# UDON SOUTH SITE DEVELOPMENT PLAN 12265 HIGHWAY 94

UDON SOUTH - COUNTY PROJECT NO. SDP XX-XXXX

SITE PLAN  
SHEET 3 OF 20

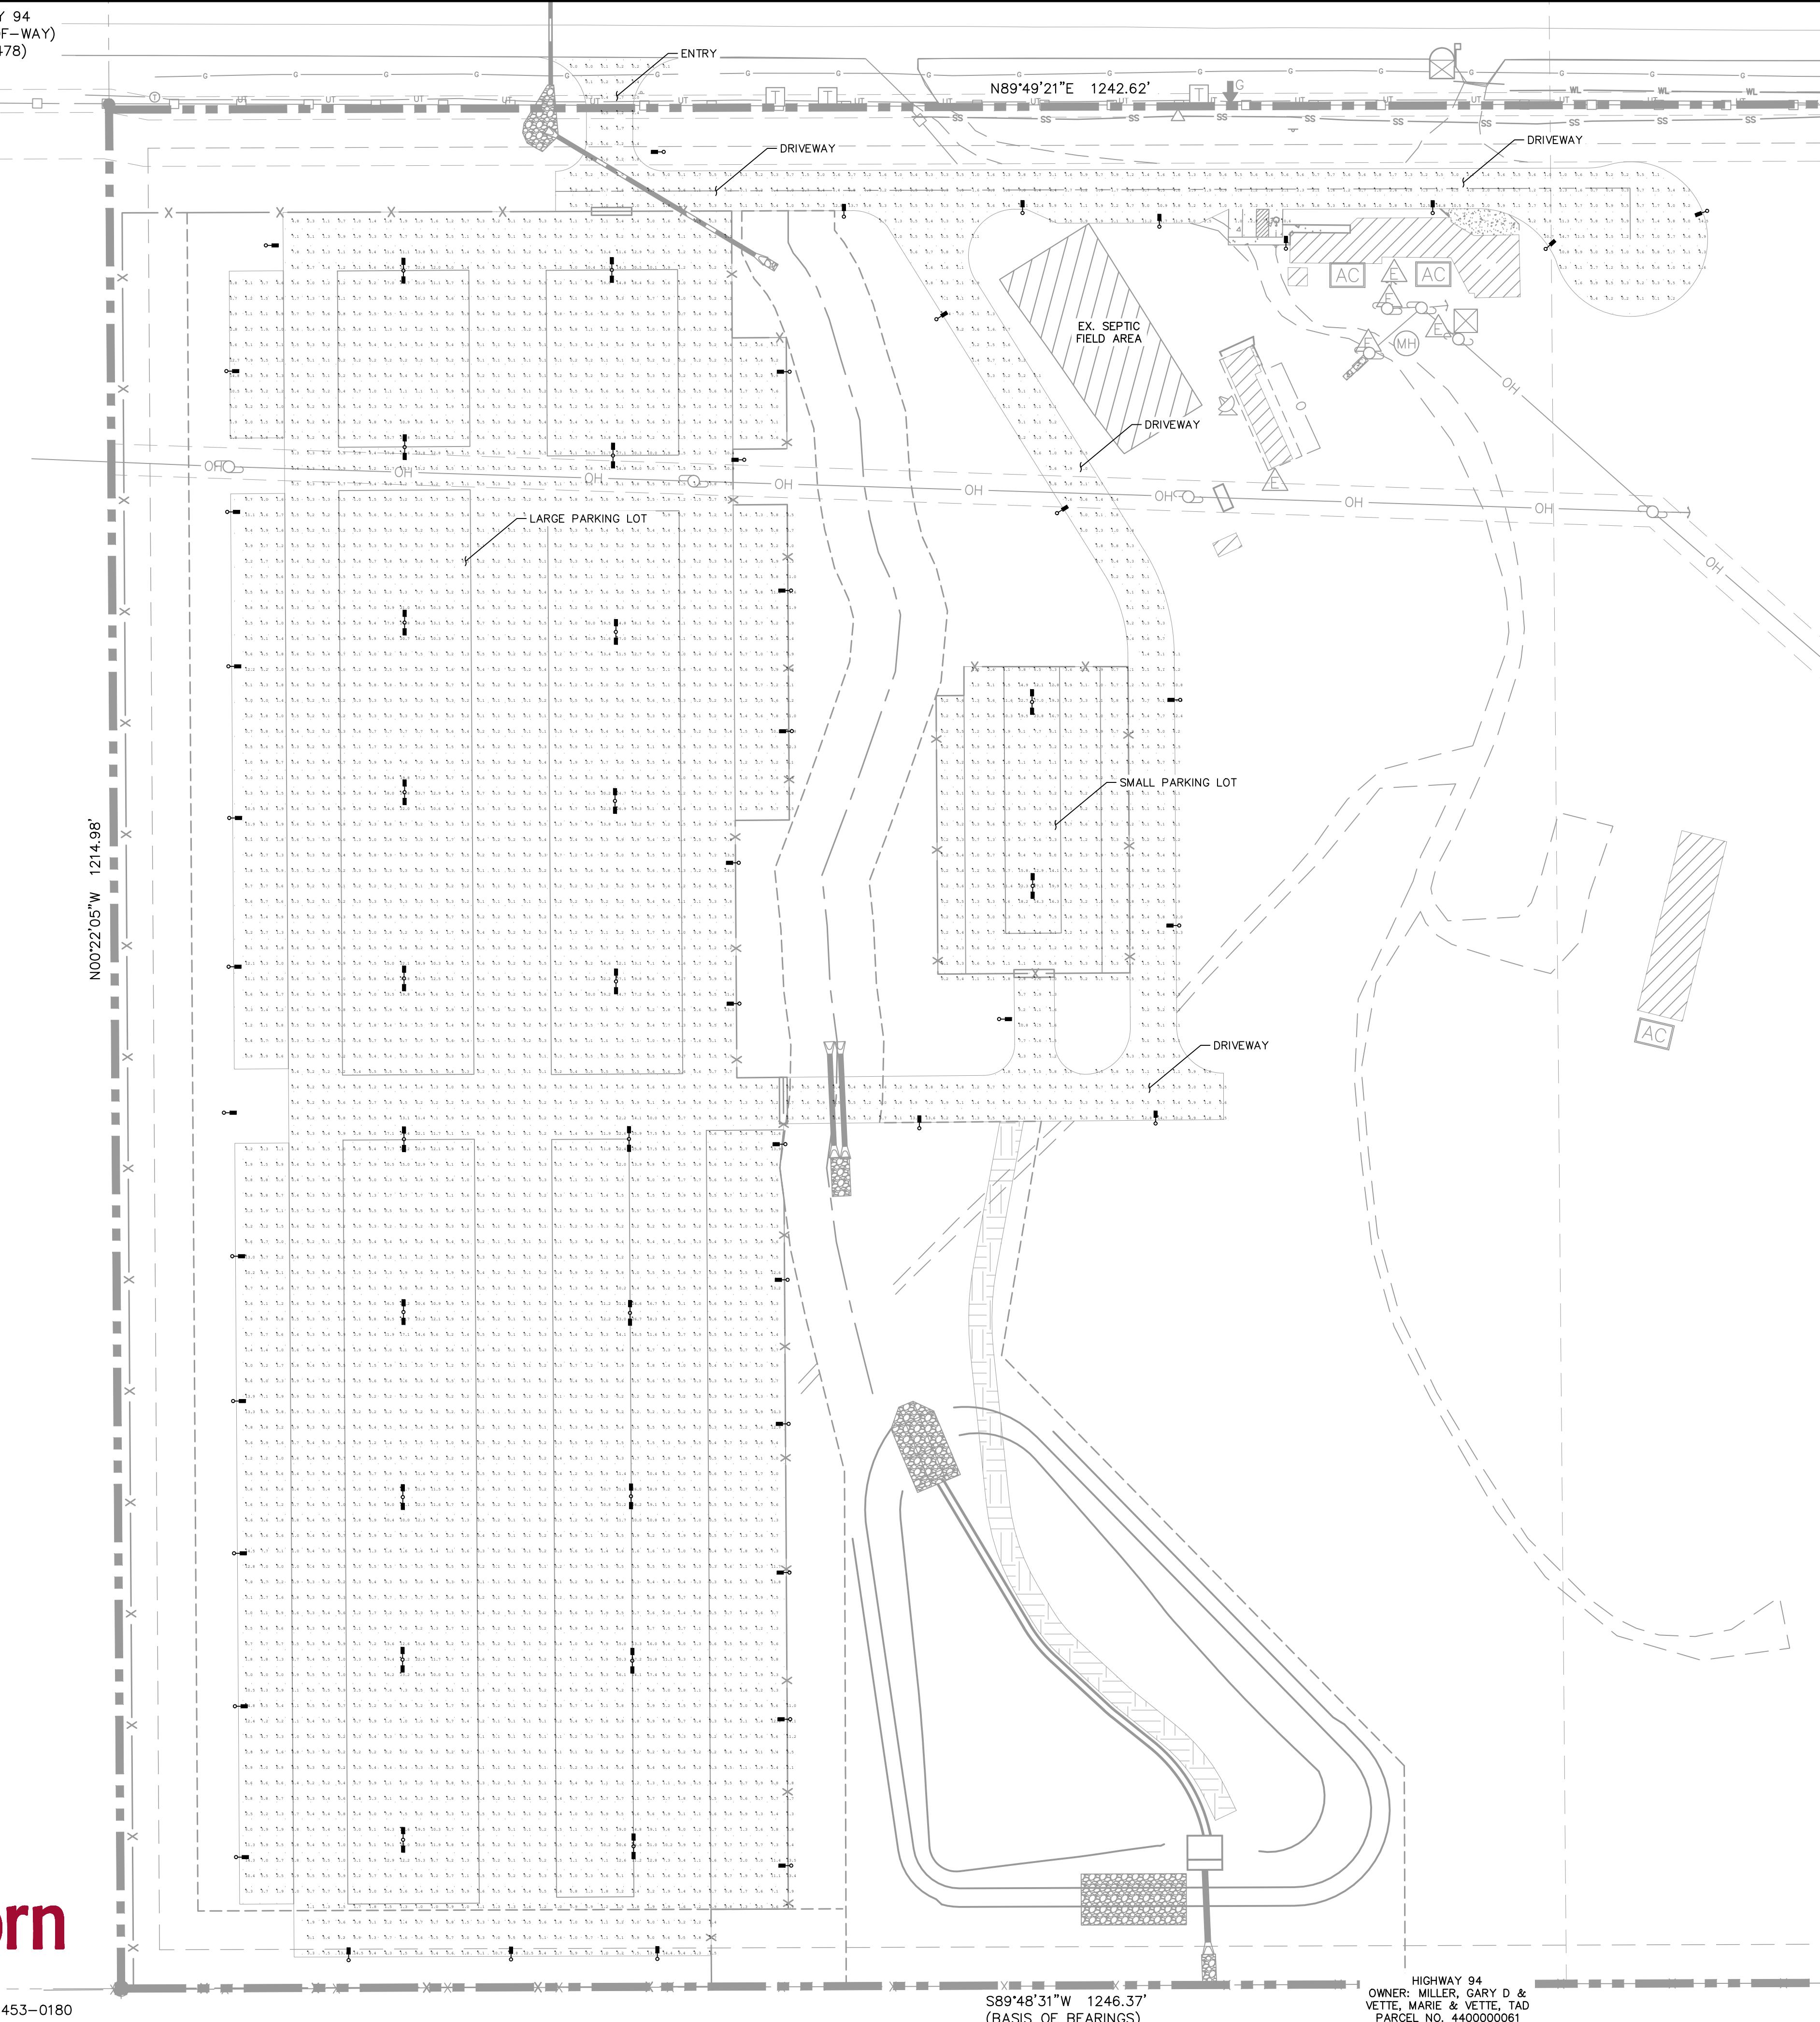
Please add a General Note to this sheet stating "CSU Field Engineer to determine final gas/electric meter, transformer and service line locations. Contact Field Engineering at 719-668-4985 (Gas) or 719-668-5564 (Electric) with any questions."
